From: Amber Willard
Sent: 11 January 2019 14:01
To: Karen Parsons
Subject: FW: P/111/18/HH

I am the case officer on your application P/111/18/HH at 5 The Crescent, Pagham.

sheet 2 a of 3

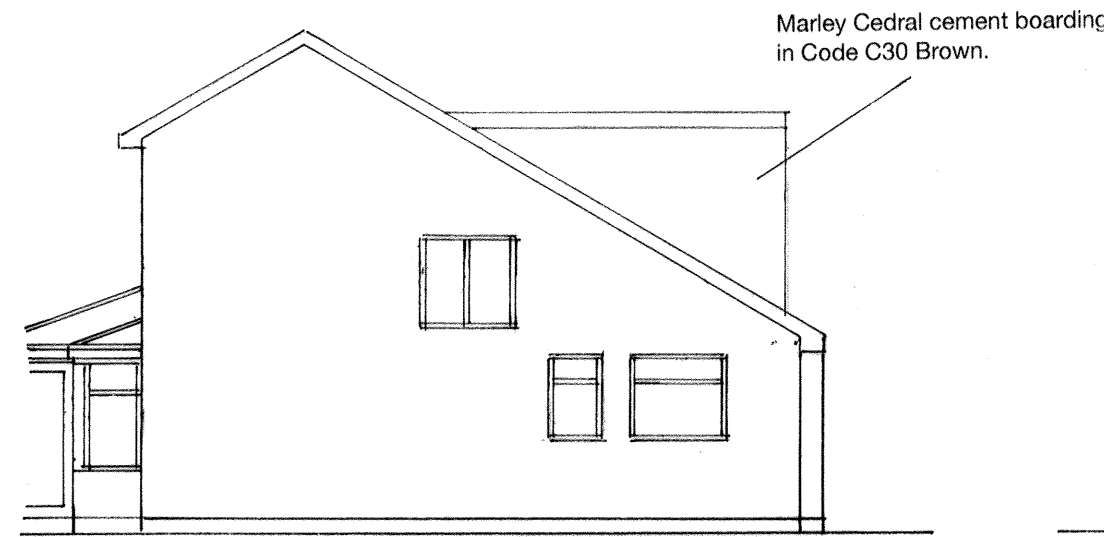
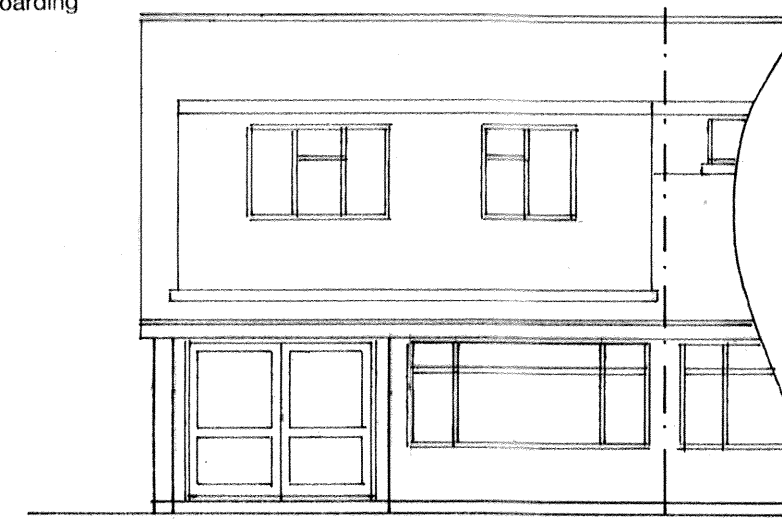
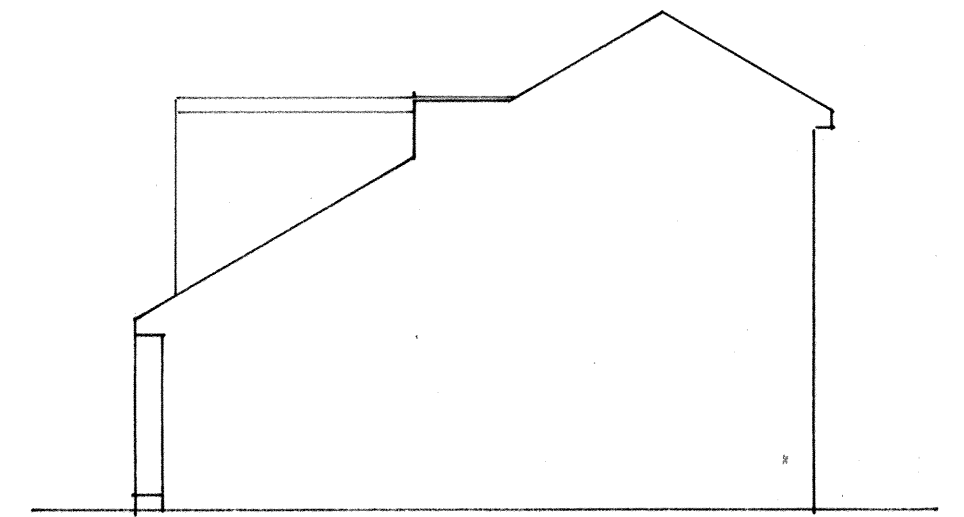
I have finished writing up the report however my manager is unhappy with the colour proposed to the front dormer. It is currently proposed Marley Cedral Cement Boarding in White however it is recommended this be altered to a brown or colour similar to the existing roof to help it blend in better with the surrounding area.

Please let me know if this is acceptable and if so am I able to have an amended plan with the colour altered to show this so it can become the approved plan.
